OXFORDSHIRE COUNTY COUNCIL'S RESPONSE TO CONSULTATION ON THE FOLLOWING DEVELOPMENT PROPOSAL

Application no: 17/00330/OUT

Proposal: Variation of Condition 5 (Drainage) of 11/00617/OUT.

Location: Land south of Blackwood Place and Molyneux Drive and North West of Cotefield Farm, Oxford Road, Bodicote.

Project	Banbury Road, Ettington, Stratford On Avon
Title	Attenuation Ponds Cross Sections

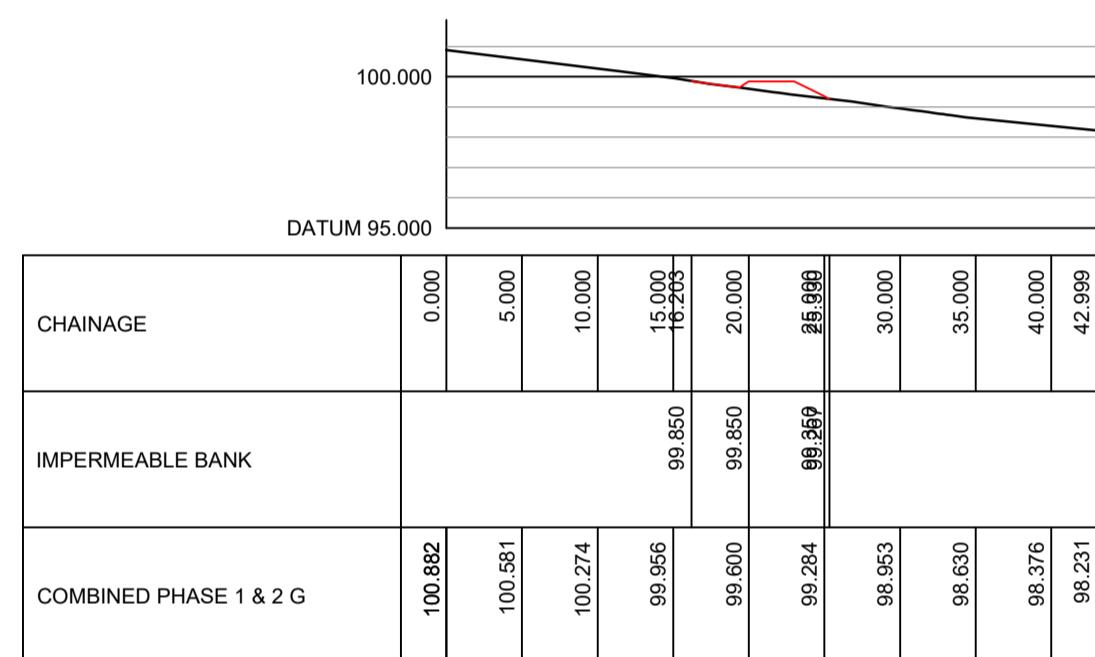
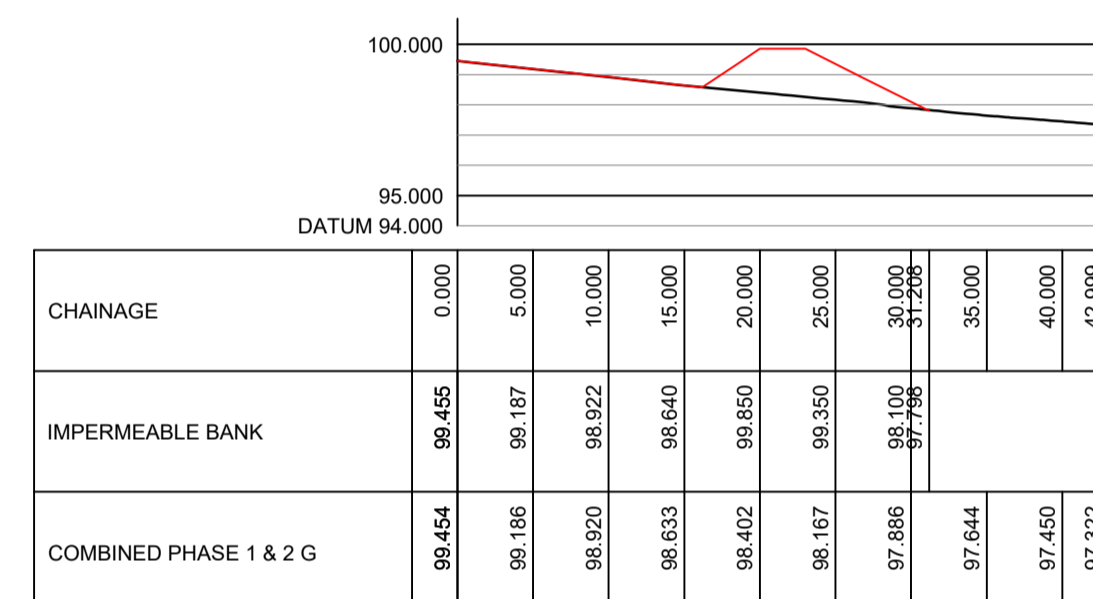
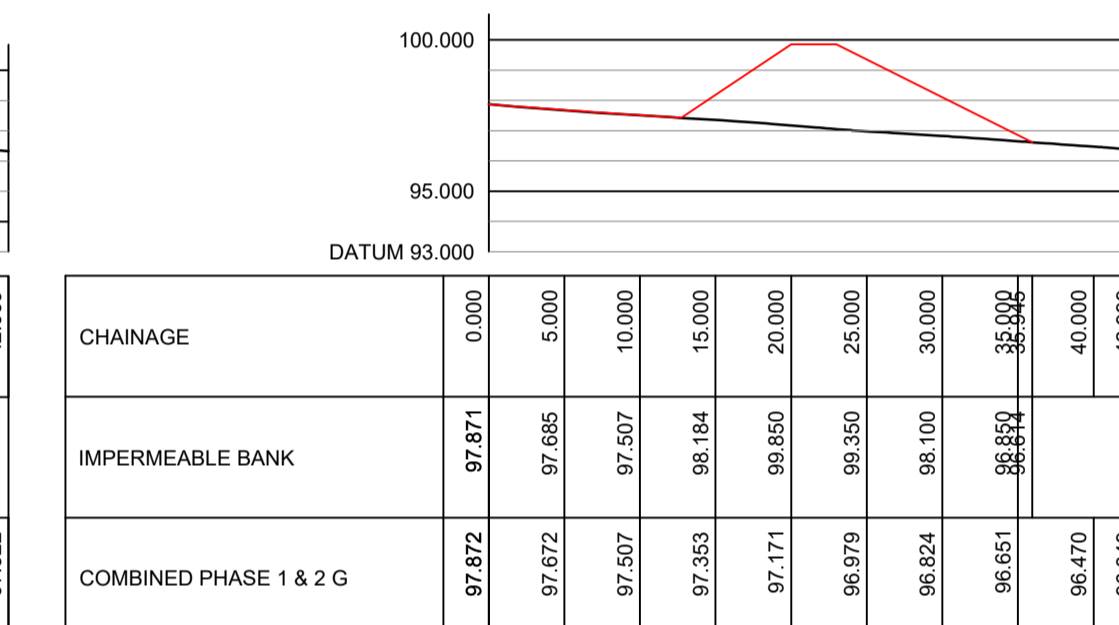
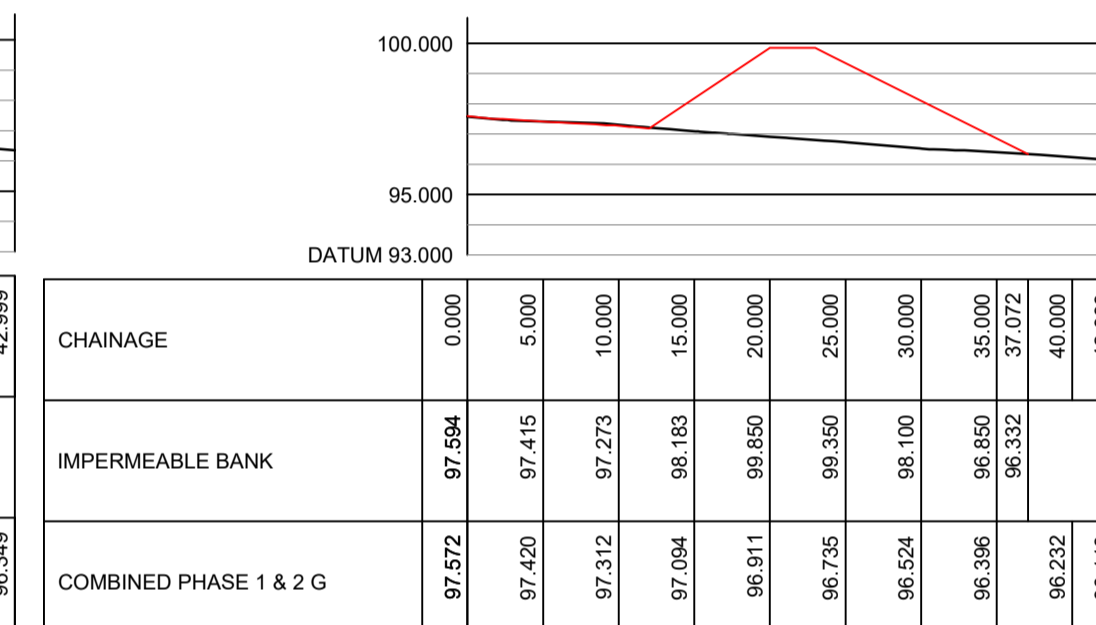
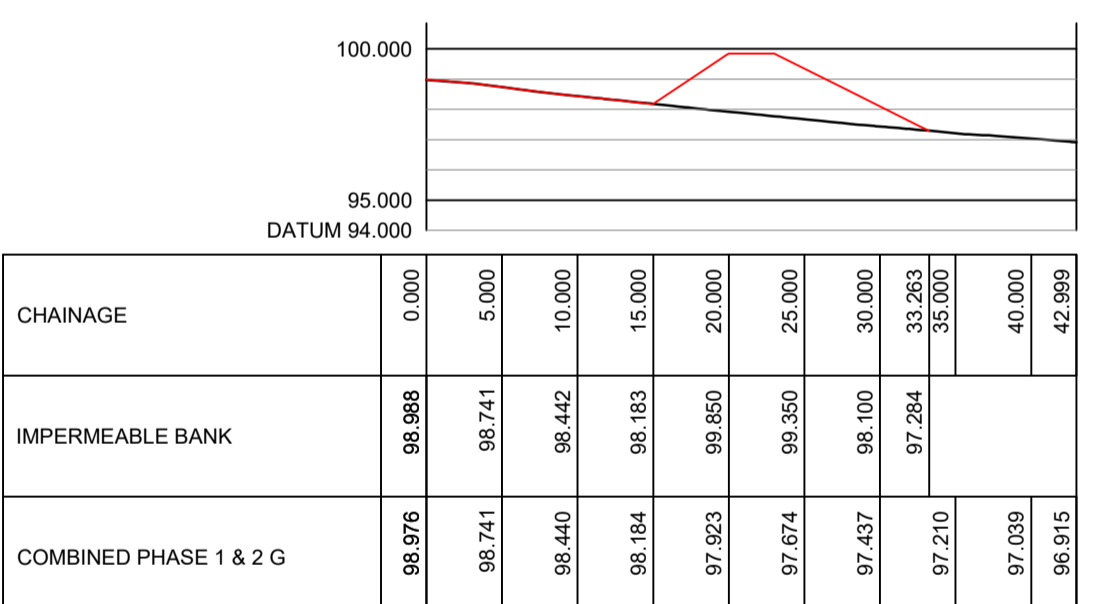
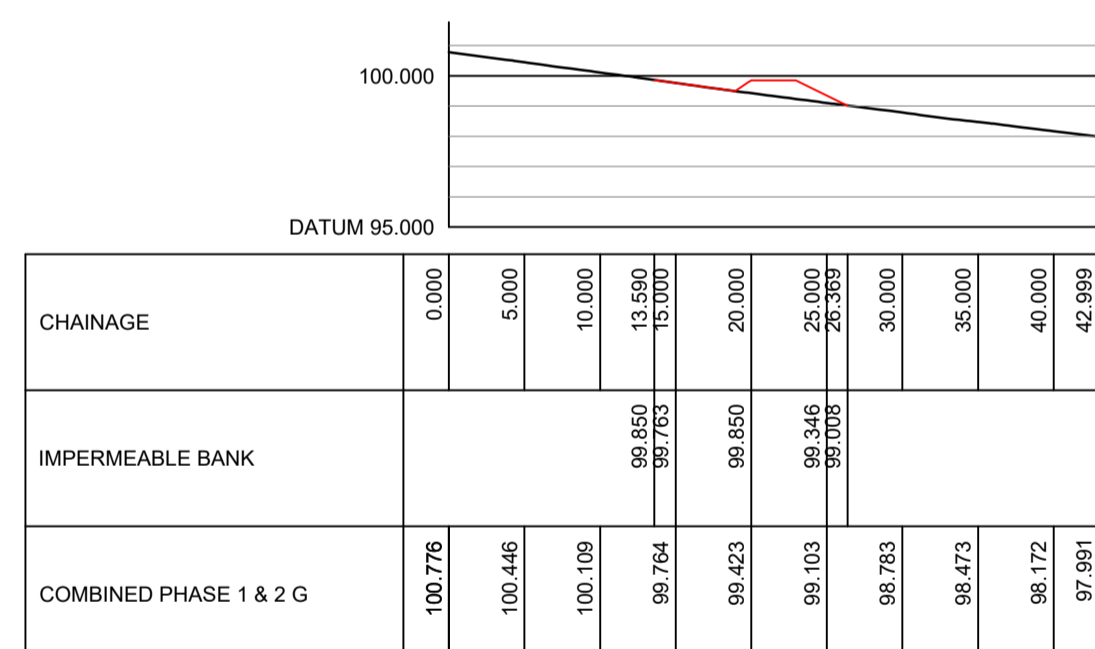
The attenuation pond design includes an emergency weir overflow structure but it is not clear where the exceedence flow would drain to when these situations arise. It appears it would flood the adjacent owners land. **(Reason for objection)**

It was unclear how access to the pond for maintenance would be carried out. **(Reason for objection).**

Soakaway Levels & Sizes

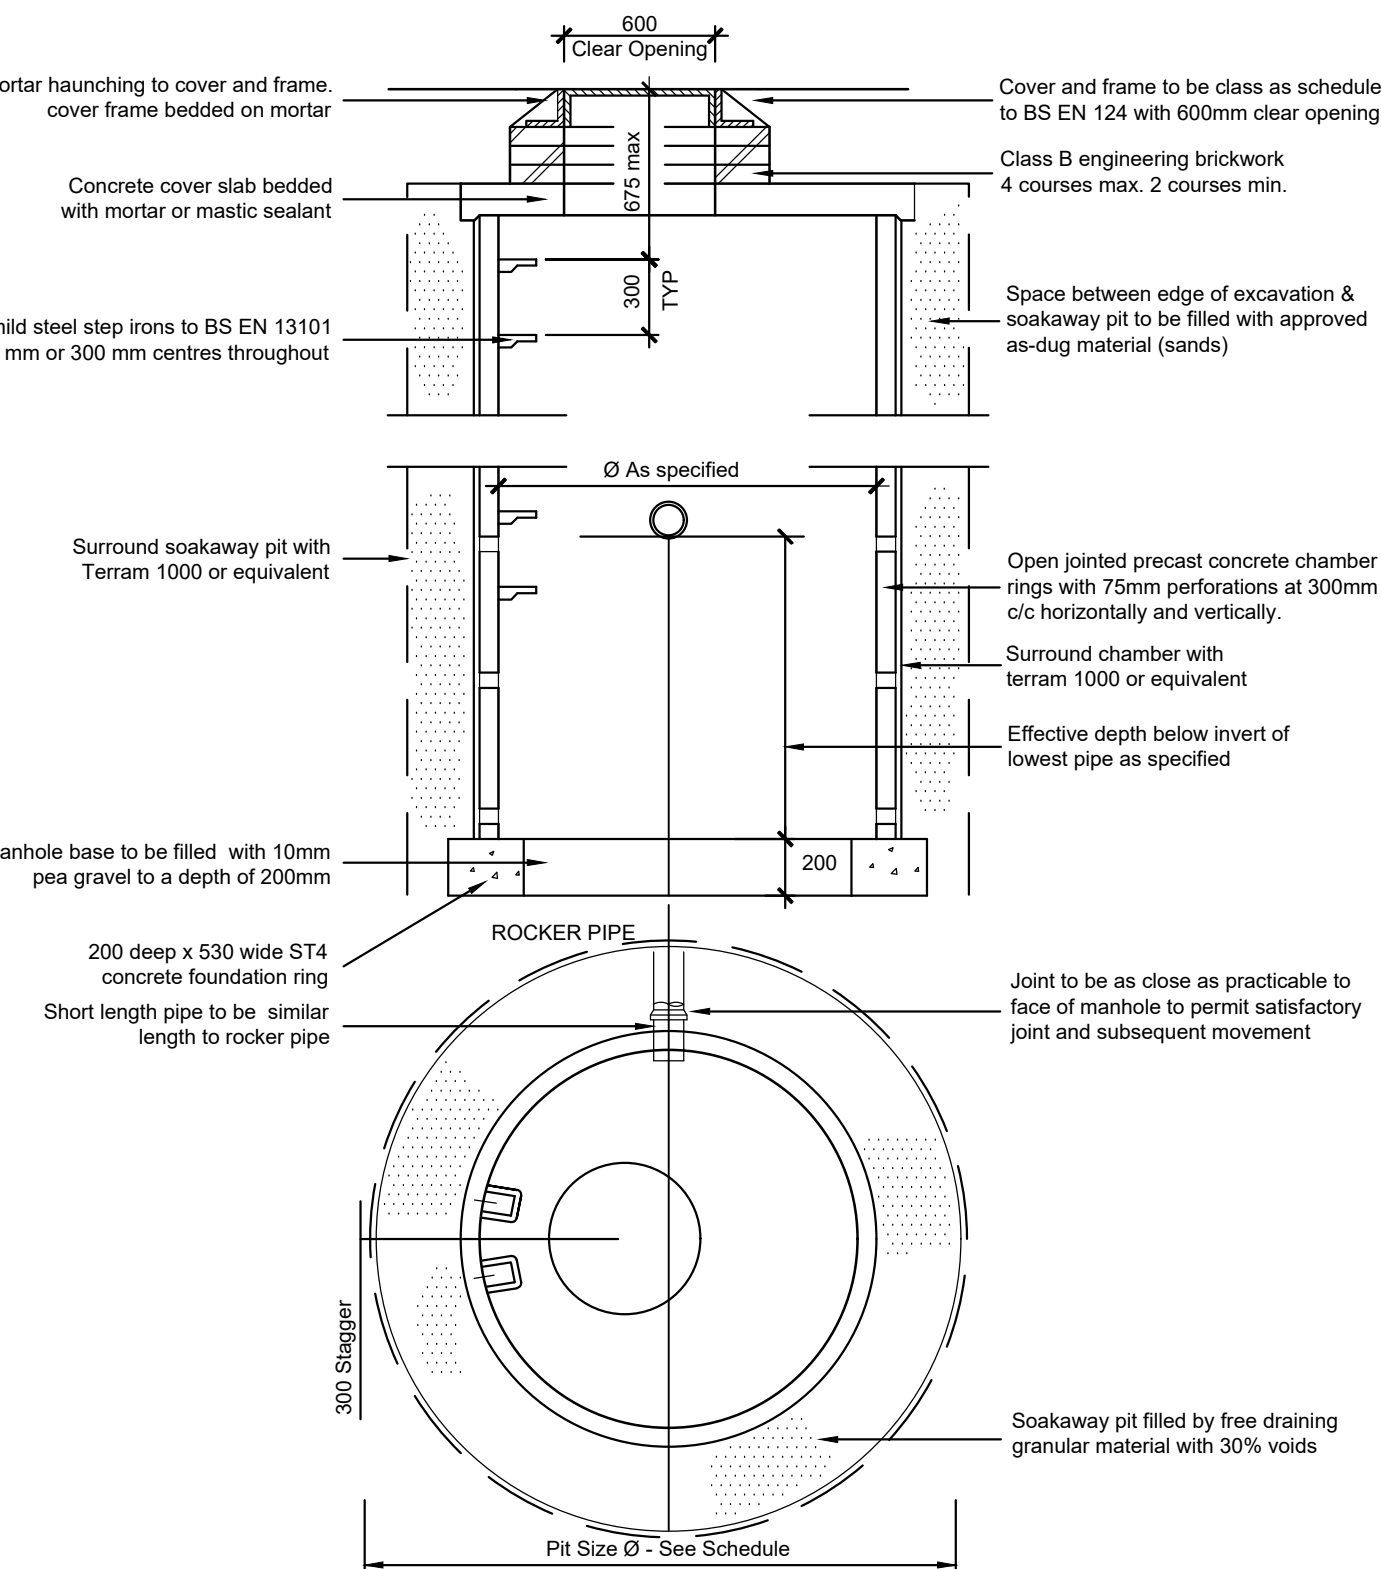
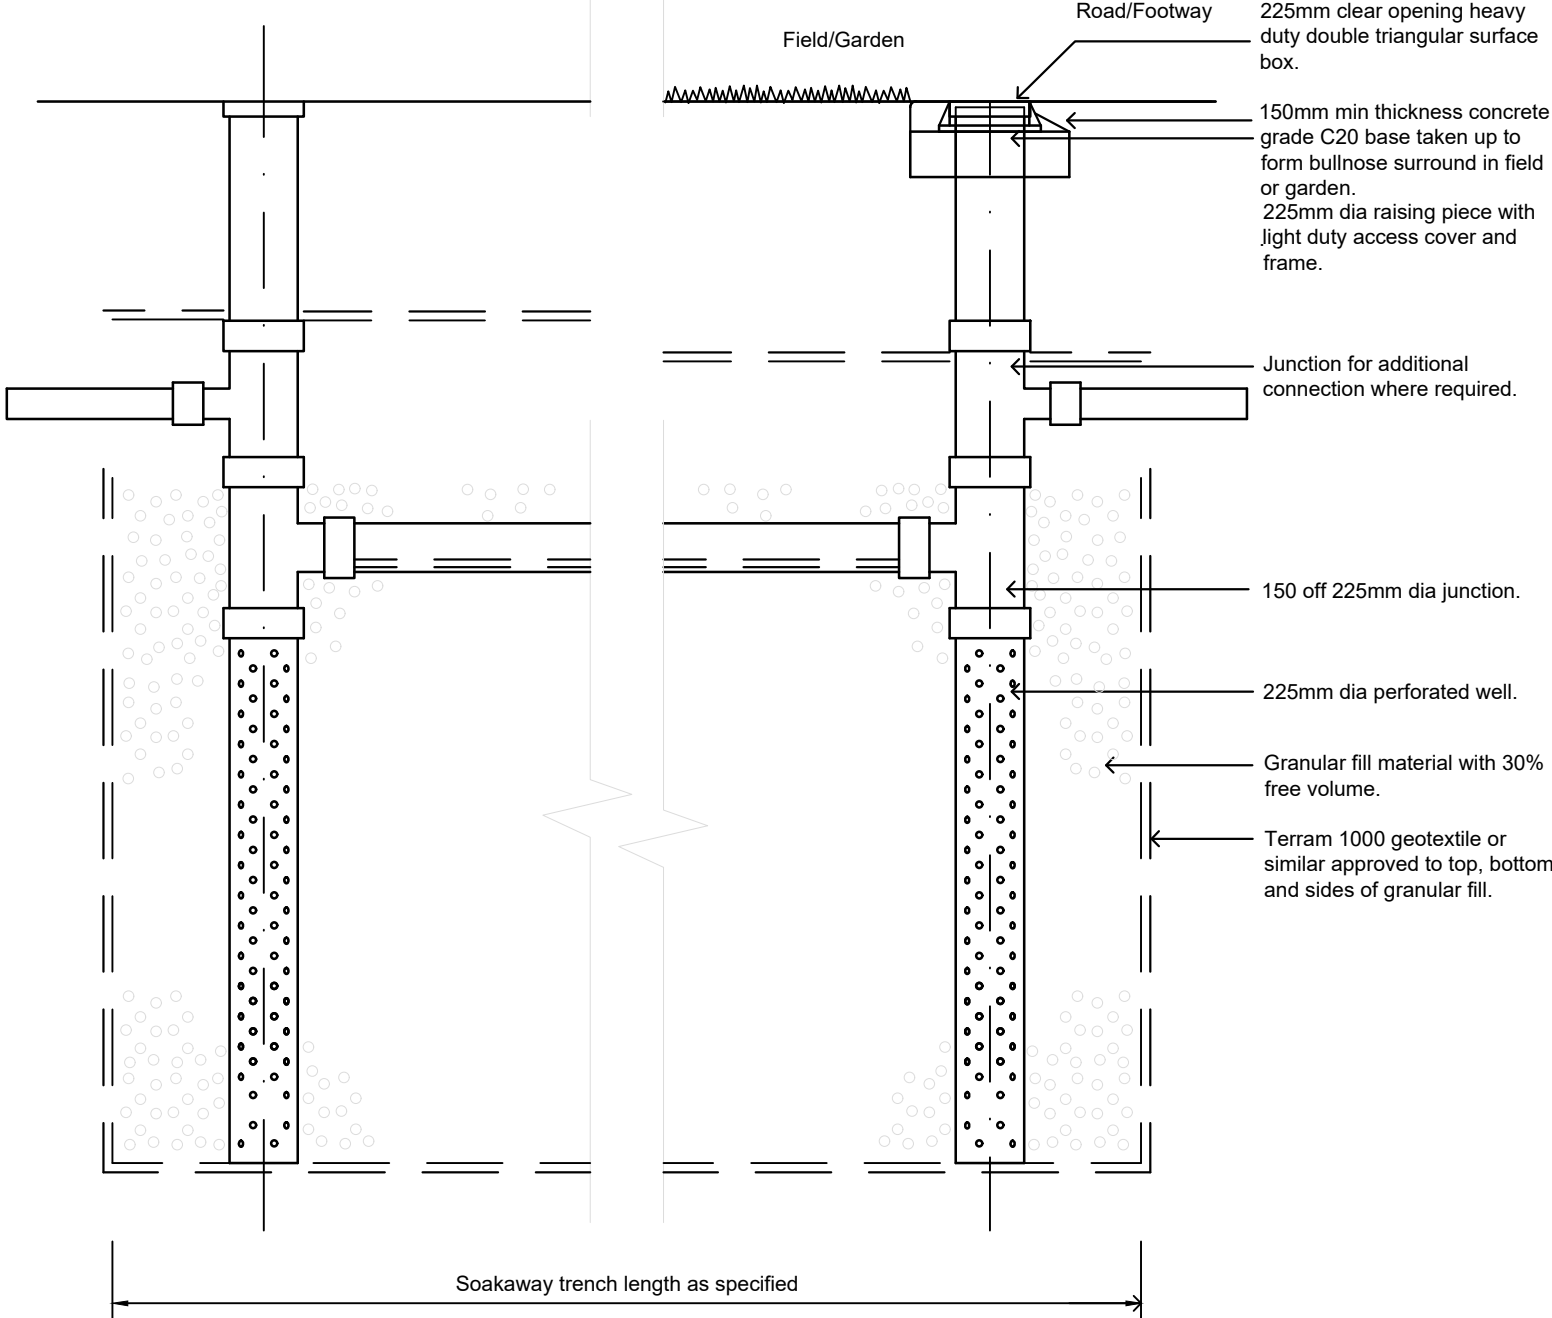
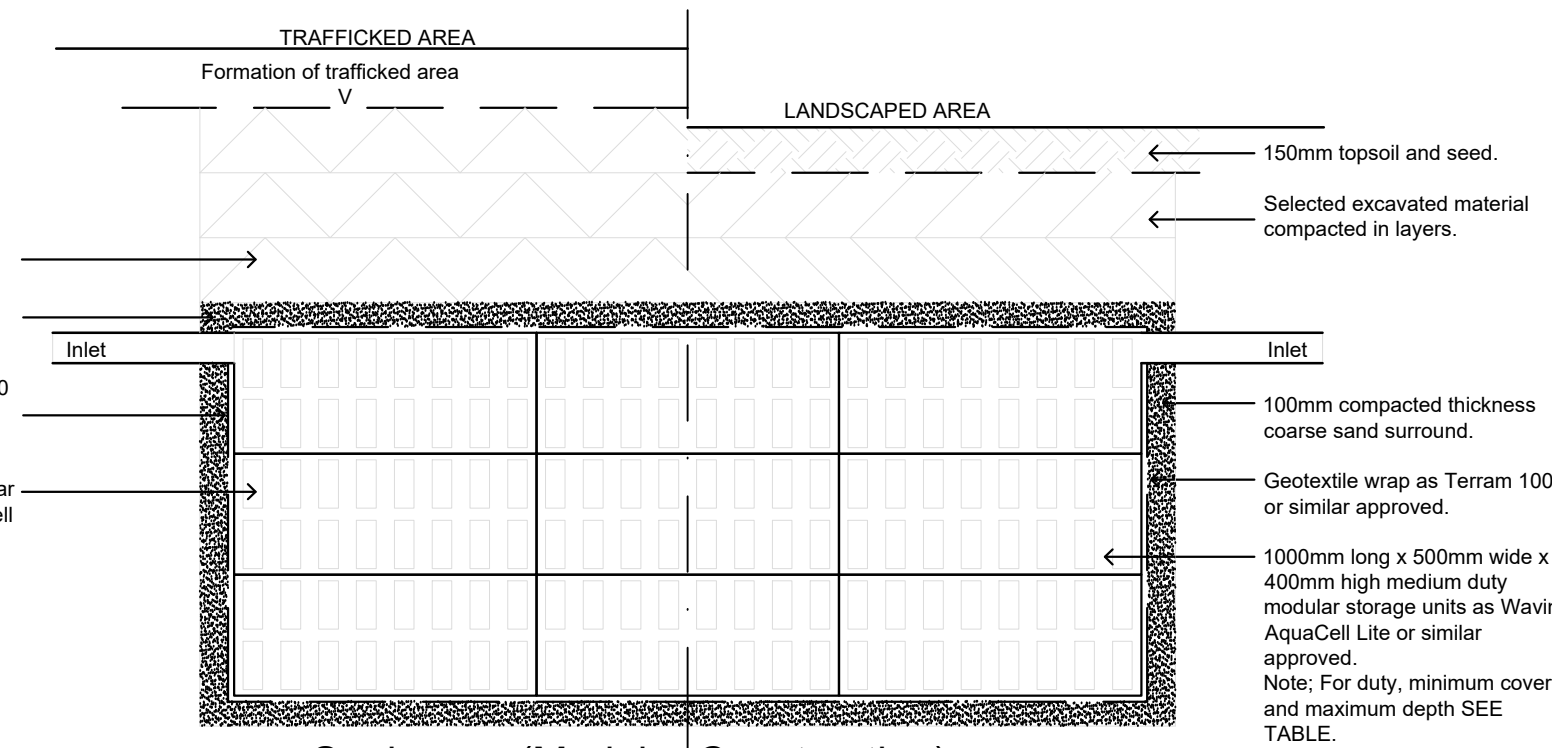
- The application drawings did not highlight any of the previous approved detail of soakaways / infiltration or rainwater harvesting facility included on previous approved plans under 11/00617/OUT. Smaller trench style soakaways appear to be seen, but these are not labelled, so OCC (drainage) is unclear as to their purpose.
